## **Response to Planning application from Hertfordshire County Council (T and CP GDP Order 2015)**

District ref: 6/2023/1221/OUTLINE  
HCC ref: WH/18059/2023  
HCC received: 29 August 2023  
Area manager: Manjinder Sehmi  
Case officer: Senober Khan

Brookmans Park Golf Club Golf Club Road Brookmans Park Hertfordshire AL9 7AT

Outline permission for the erection of 14 dwellings, with all matters reserved except for access

OLYMPUS Twin Pack - 6x4 Wide - Smooth Body RCV

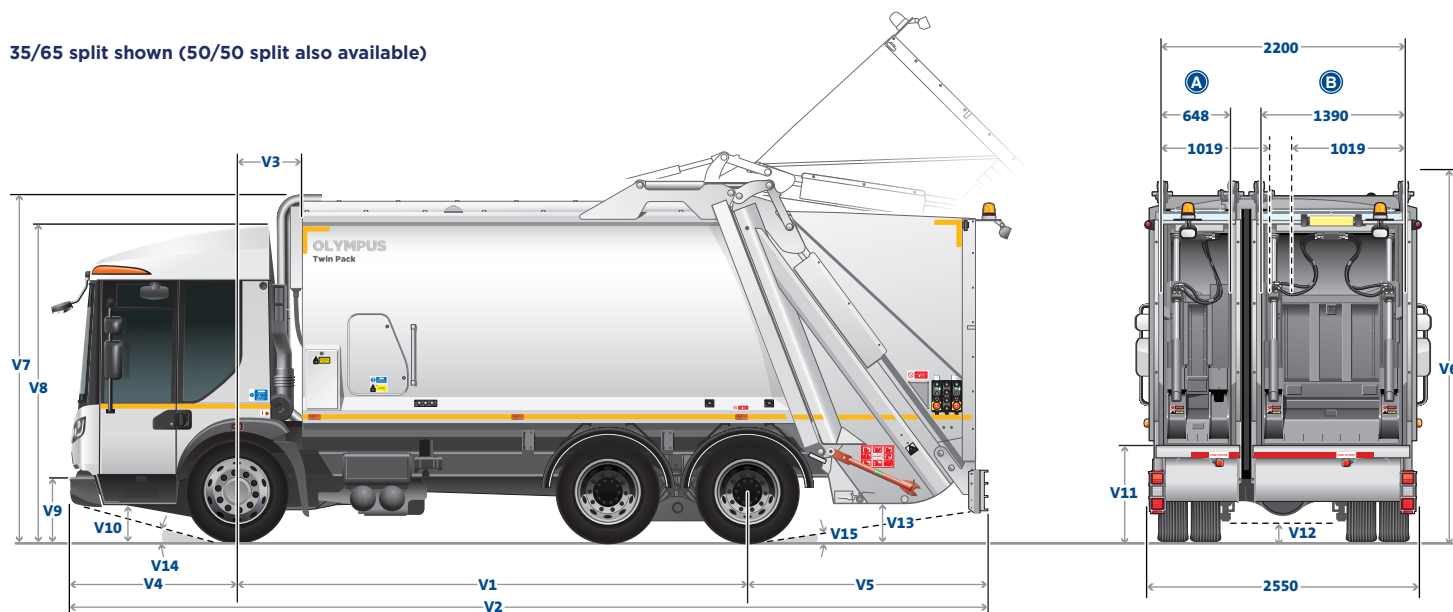
The swept path drawings show that the proposed vehicle access bellmouth would be very tight for refuse vehicles to make the turning manoeuvres, with very little margin of error and will be kerb to kerb, making it very difficult for refuse vehicles to turn into and out of the site in one move if error in turning is made requiring multiple manoeuvres to turn. The HA feels this is likely to require the proposed vehicle access to be set back into the site in order to provide the required depth needed to show a vehicle will be able to turn and egress from the bay in forward gear with at least 0.5m clearance between the track and the kerbs.
